Re: MMC Congress Building | 22 Bramhall St | Level III Site Plan
Response to City Reviewer Comments 1

Comments from Transportation Project Manager – Bruce Hyman Dated October 10, 2018

Comments from City of Portland Civil Engineering Consultant – Wright Pierce Dated October 10, 2018

Drawing file: Original Submittal / 16 Details, Stormwater System sht C30-04.pdf

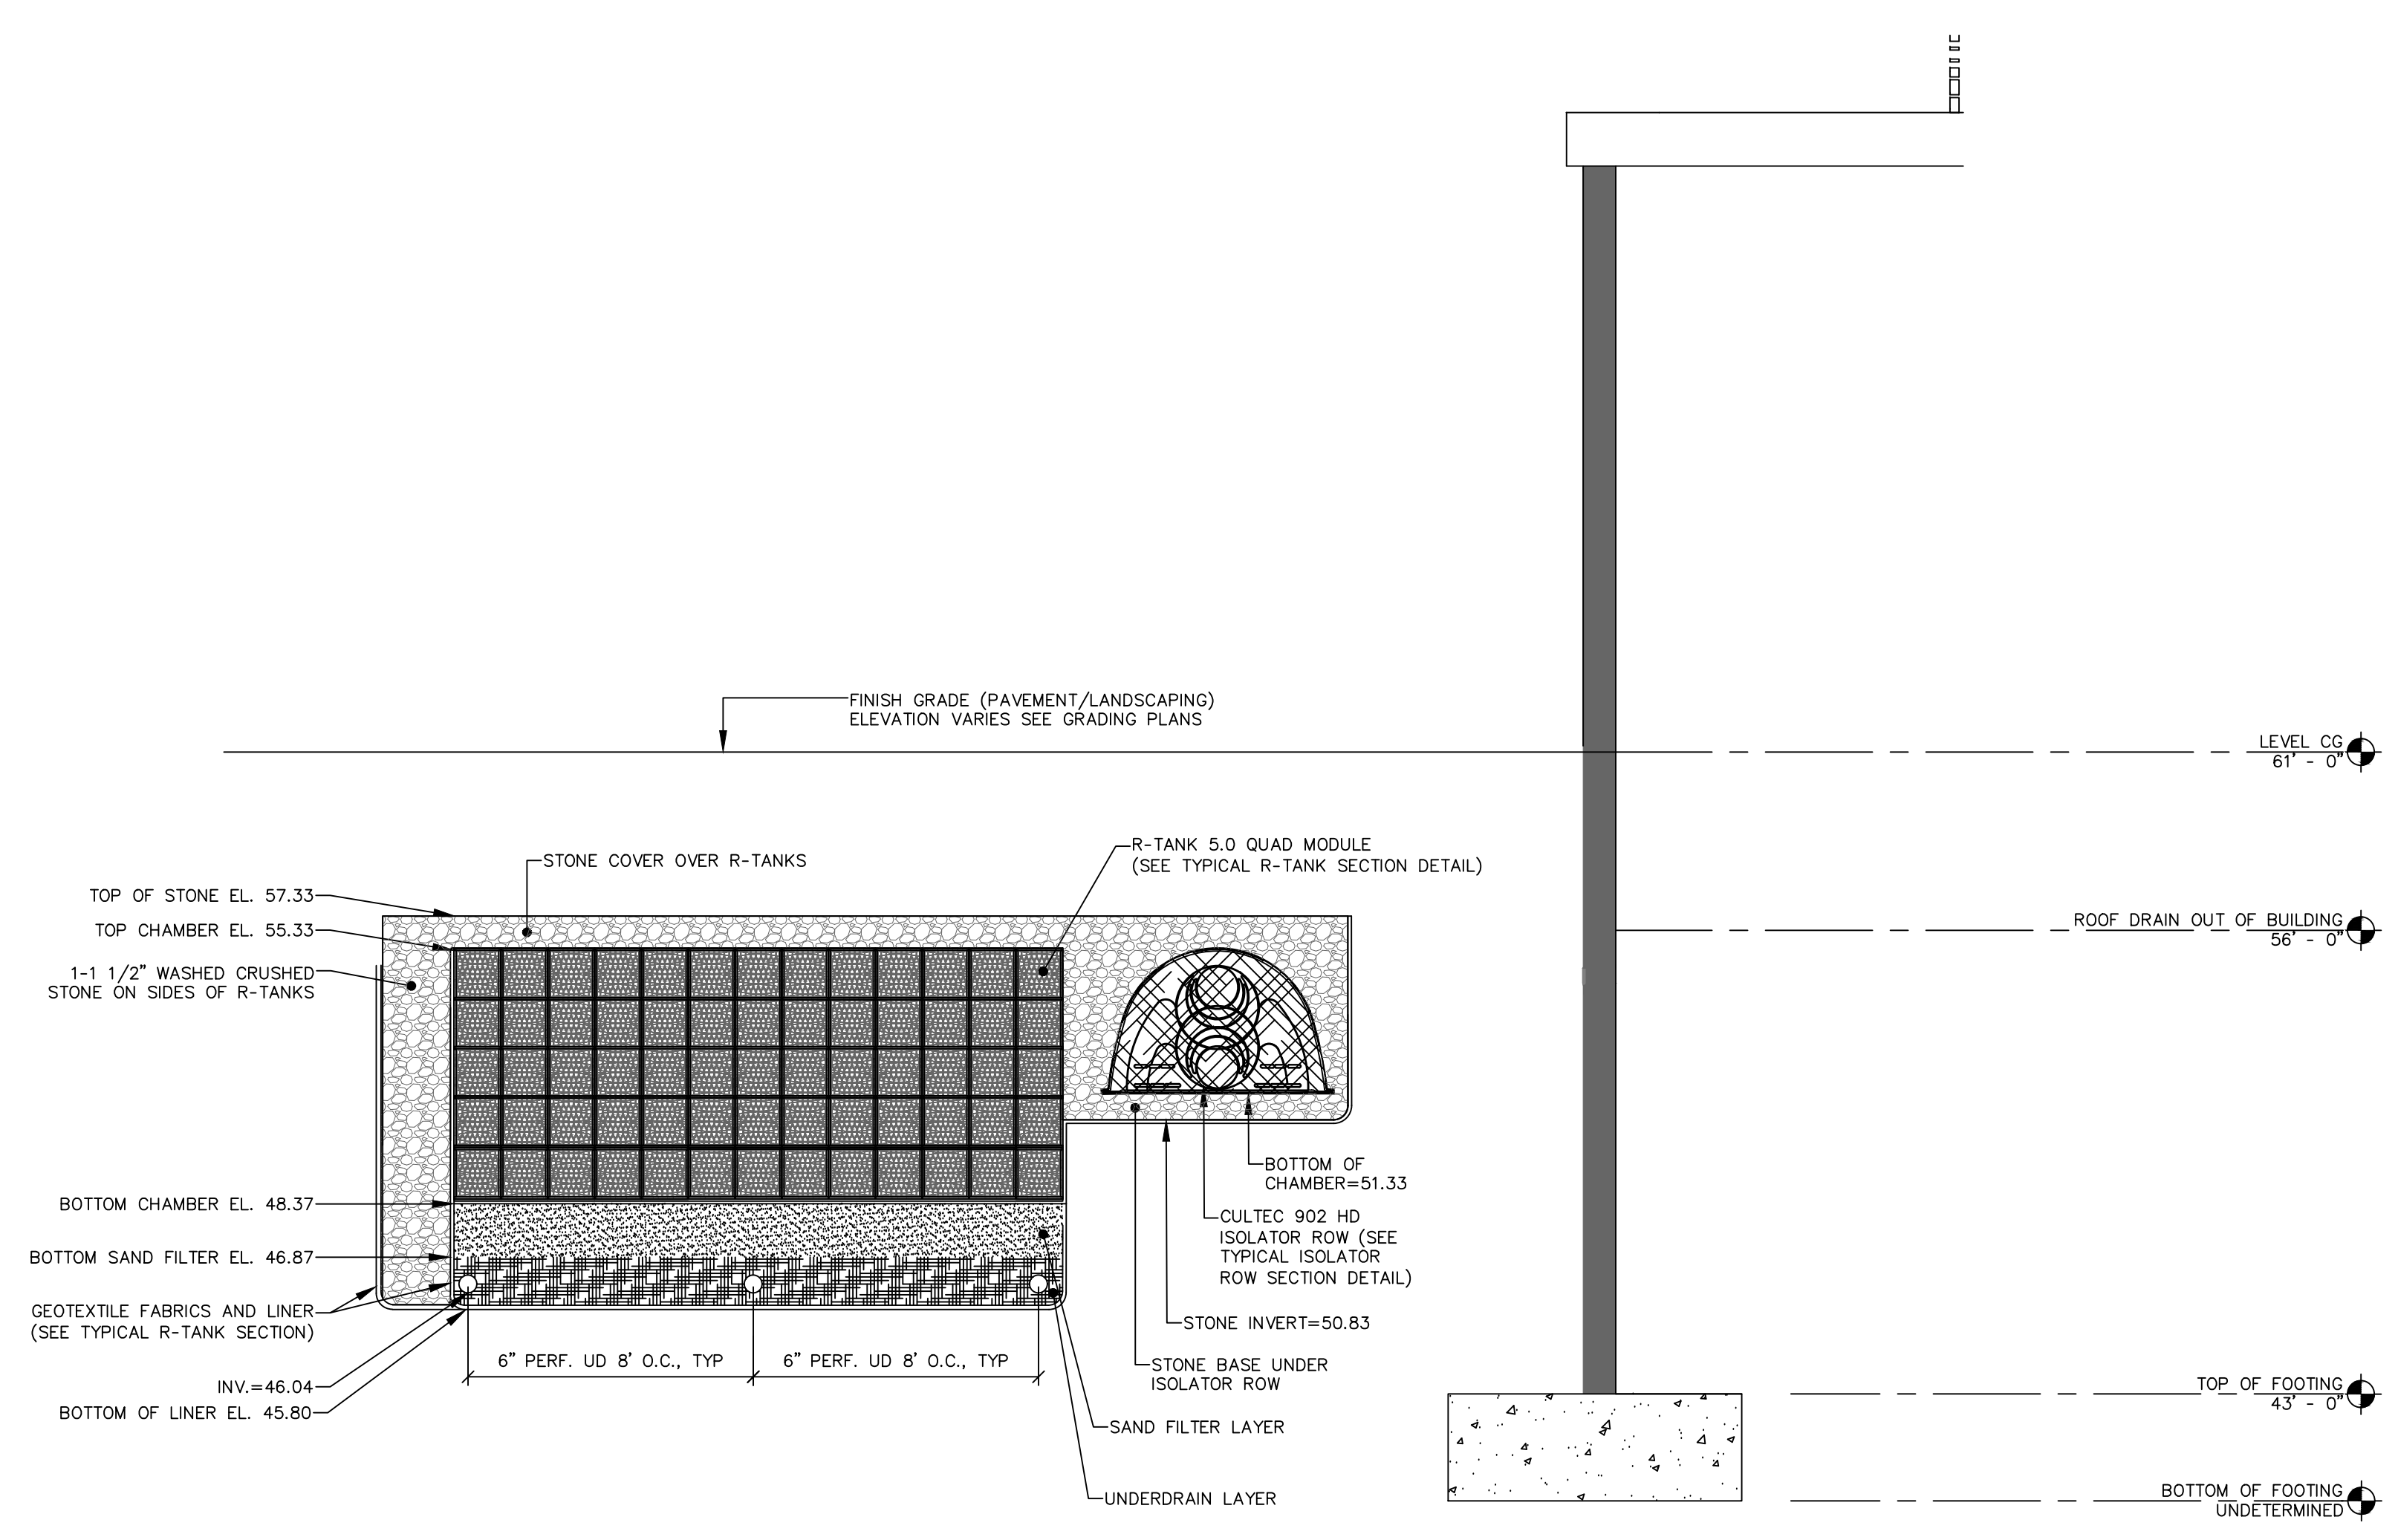
- ii. *“Subsurface Sandfilter Section” details match the HydroCAD model. Additional pipe invert, pipe length, and pipe size information on grading plans and details are needed to confirm that the HydroCAD model matches permitting plans.*

C11-01 and Sheet C30-01. An outlet control structure detail has been added to sheet C30-04.

SHEET NUMBER
C04-01

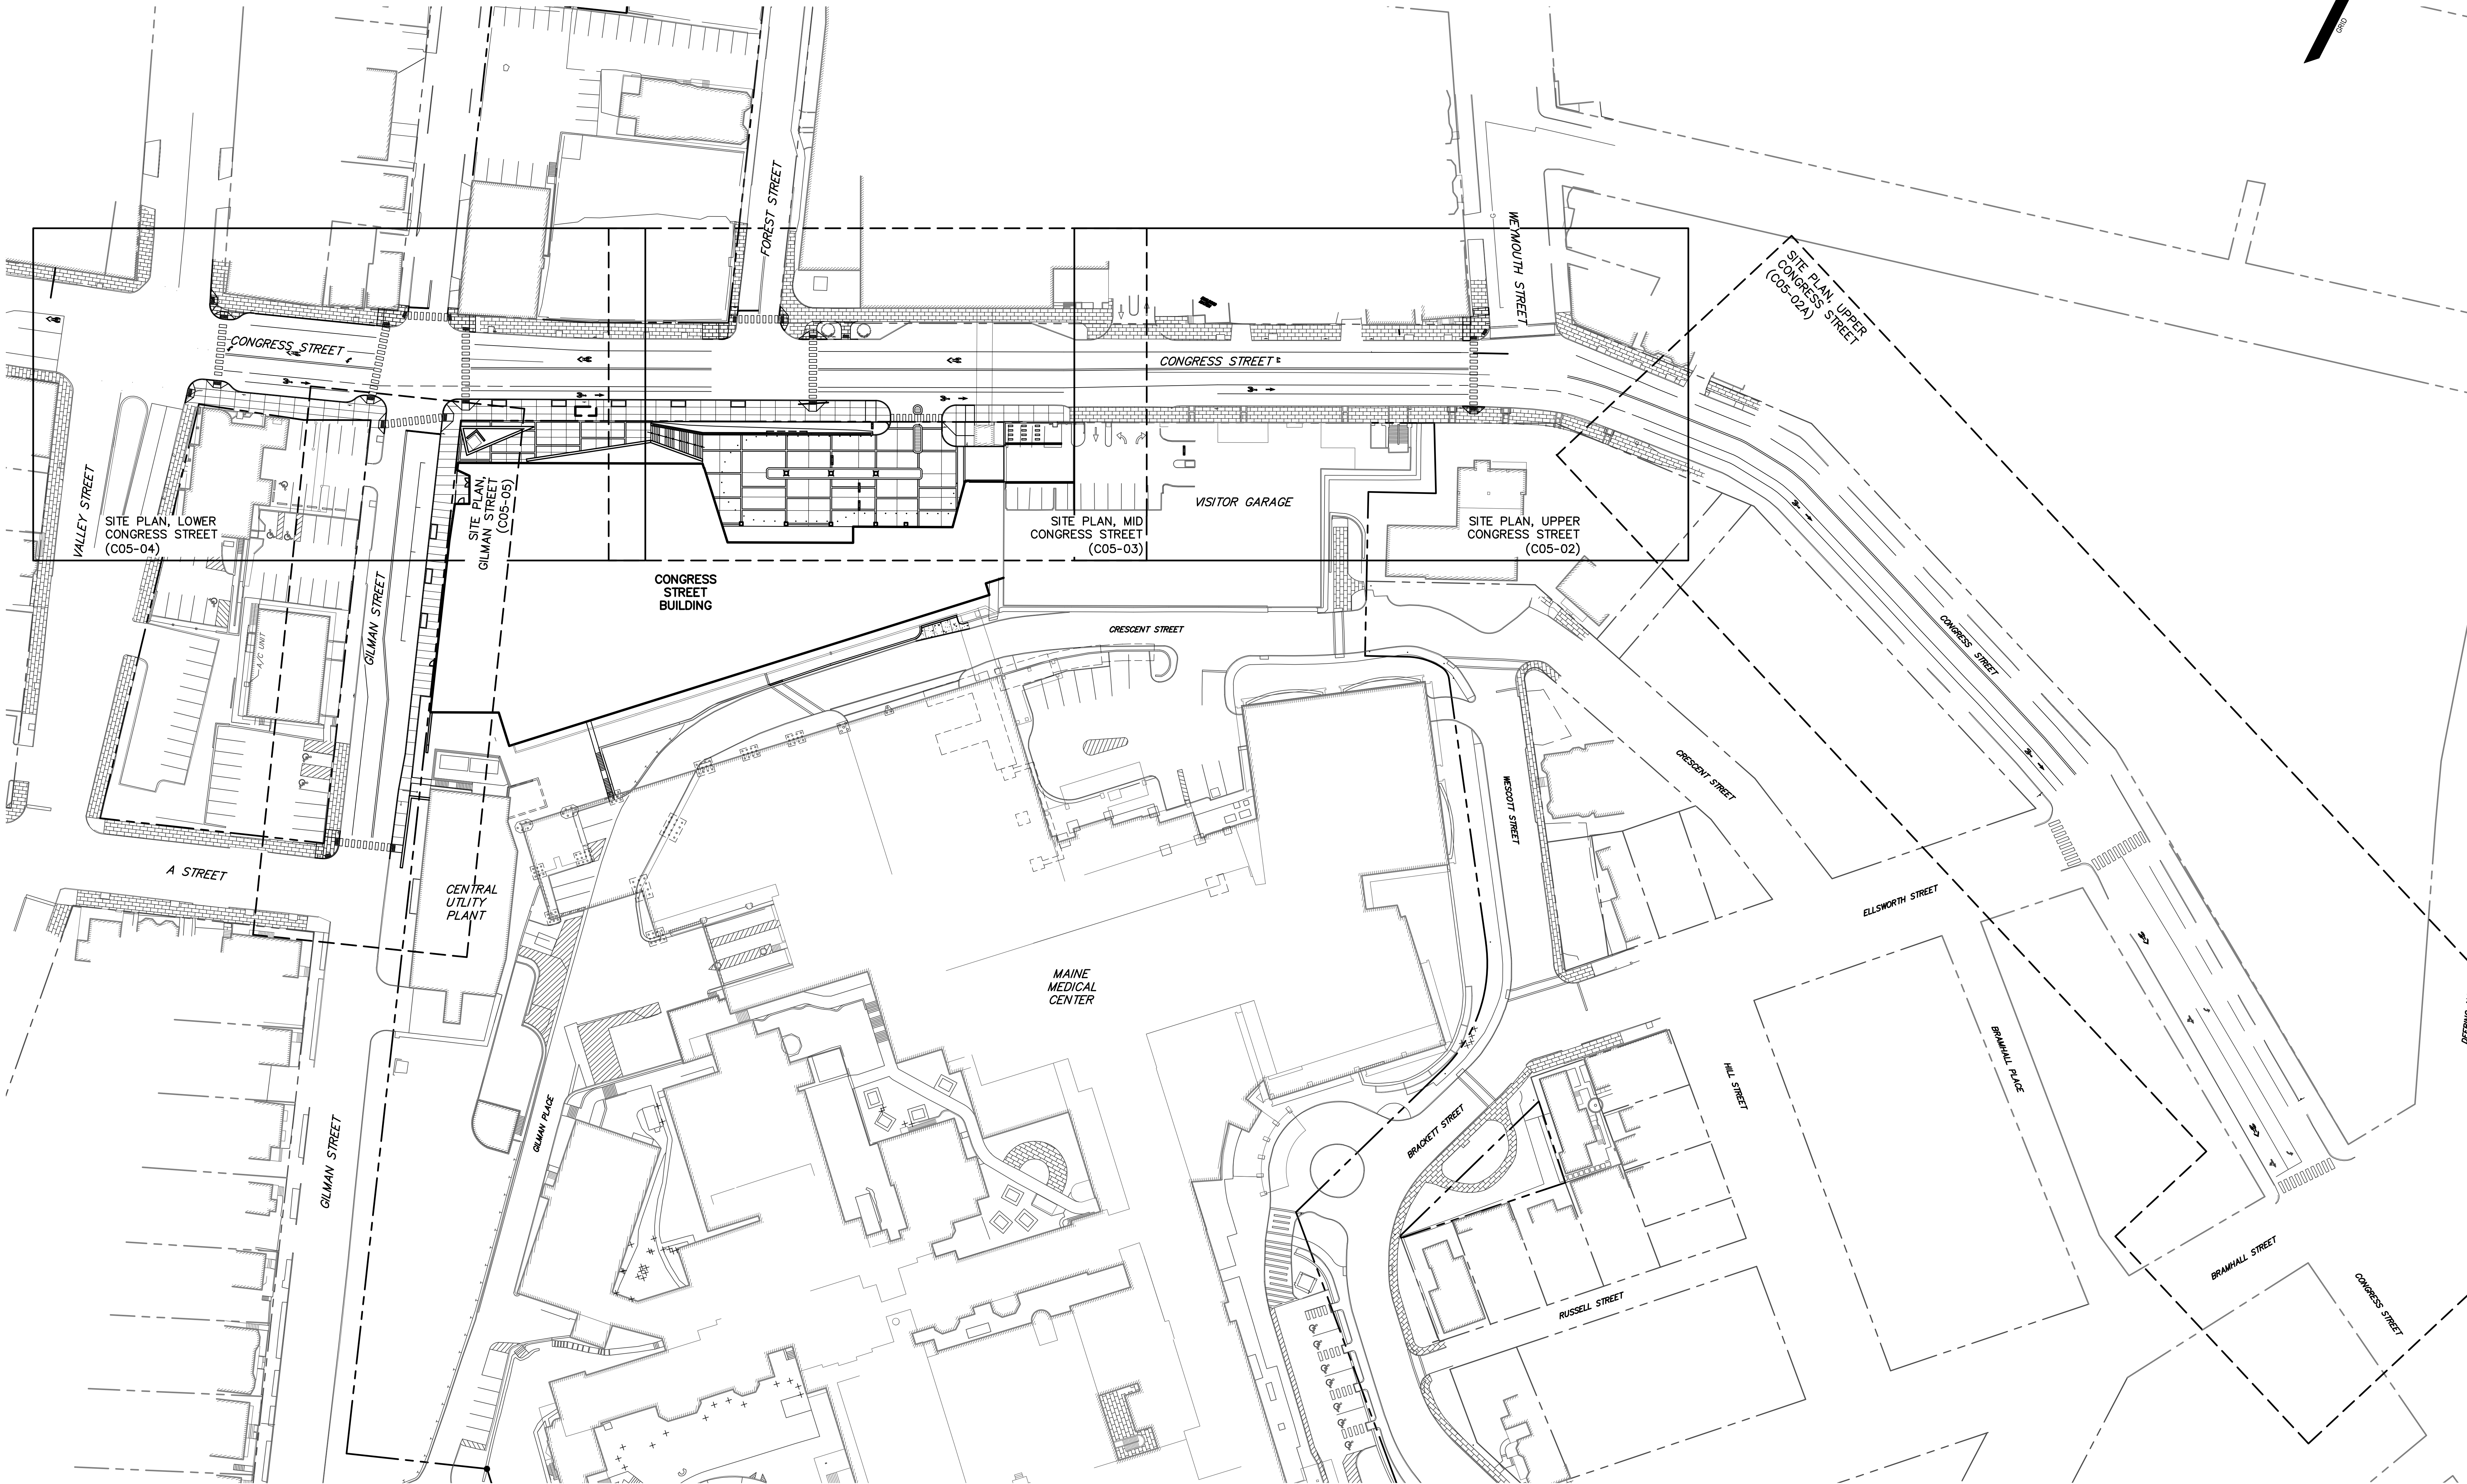
iv. *Location of Erosion and Sedimentation Control best practices were not observed on the Demolition Plan or Site Grading Plans. The applicant shall provide this information.*

Response: The location of erosion and sedimentation control measures has been added to the Demolition plan Sheet C04-01. Stabilized entrances are provided at the locations of the gated entrances identified on the Construction Management plan. As indicated in the Construction Management Plan, the majority of site disturbance will be internally drained, occurring below grade, behind temporary earth retention walls. Recommended locations for construction dewatering filter bag locations are indicated on Sheet C04-01.
